PRELIM ELEVATIONS

PROJECT NAME:
PROPOSED DRIVE THRU SHELL
PROJECT ADDRESS:
NWC STRUTHERS RD & NORTH GATE
BLVD
COLORADO SPRINGS, CO
80921

SHEET TITLE:
PRELIM Elevations

SHEET NUMBER:
18

ELEVATIONS

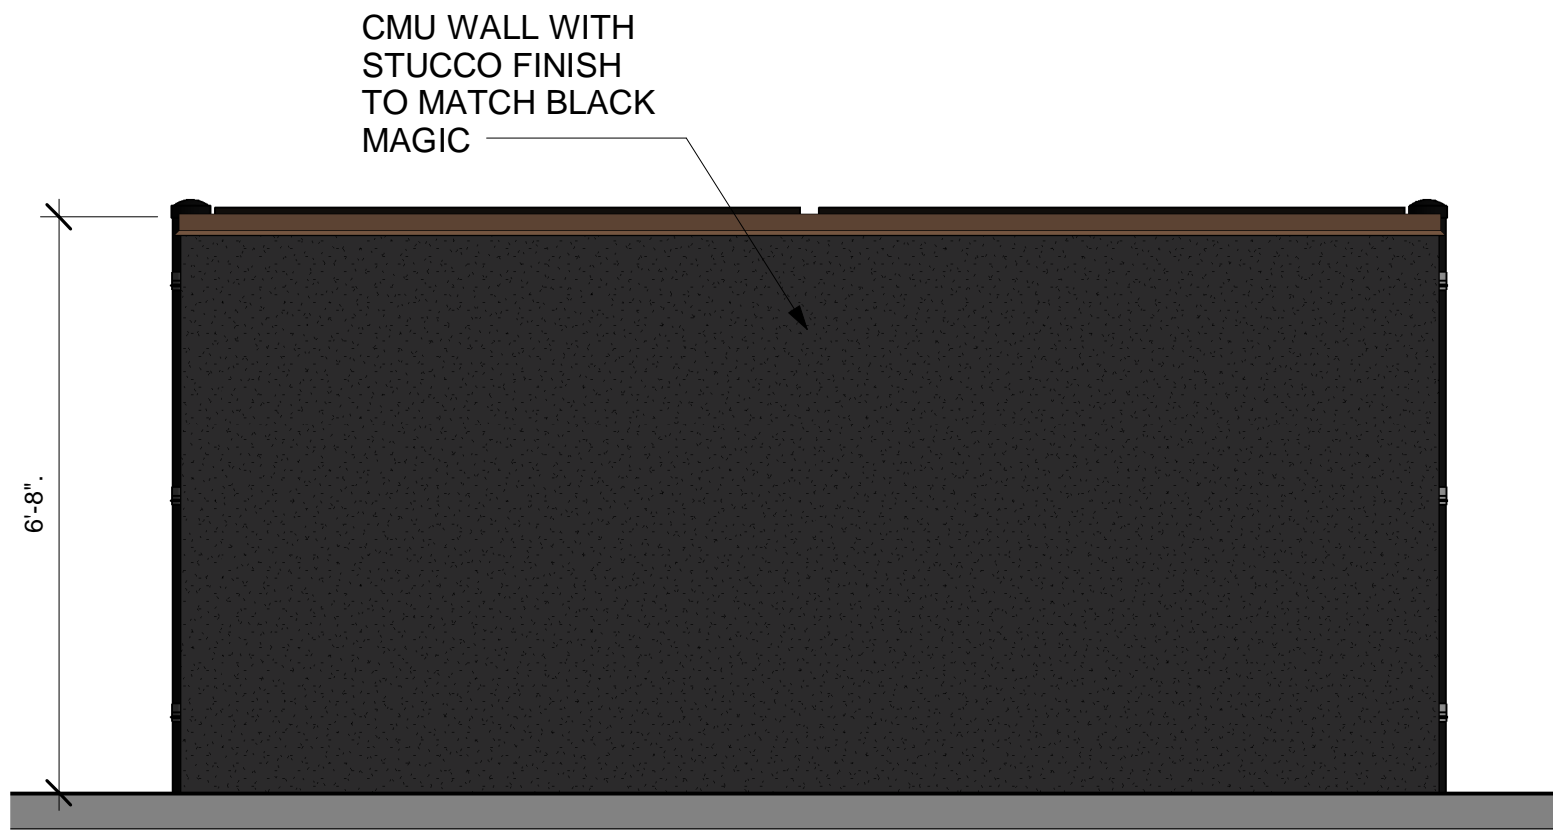
Is this iron? where are the access gates?

Provide all elevations (north, south, east, and west) and provide reference to grade.

What are the surface materials? Is this black?

Is this correct 12' fence? Any fence over 7' is a structure and must meet building setbacks. Structures are not allowed within landscape setbacks. How is the 12' fence visually compatible to residents?.

What are the surface materials? Is this brown vinyl siding?
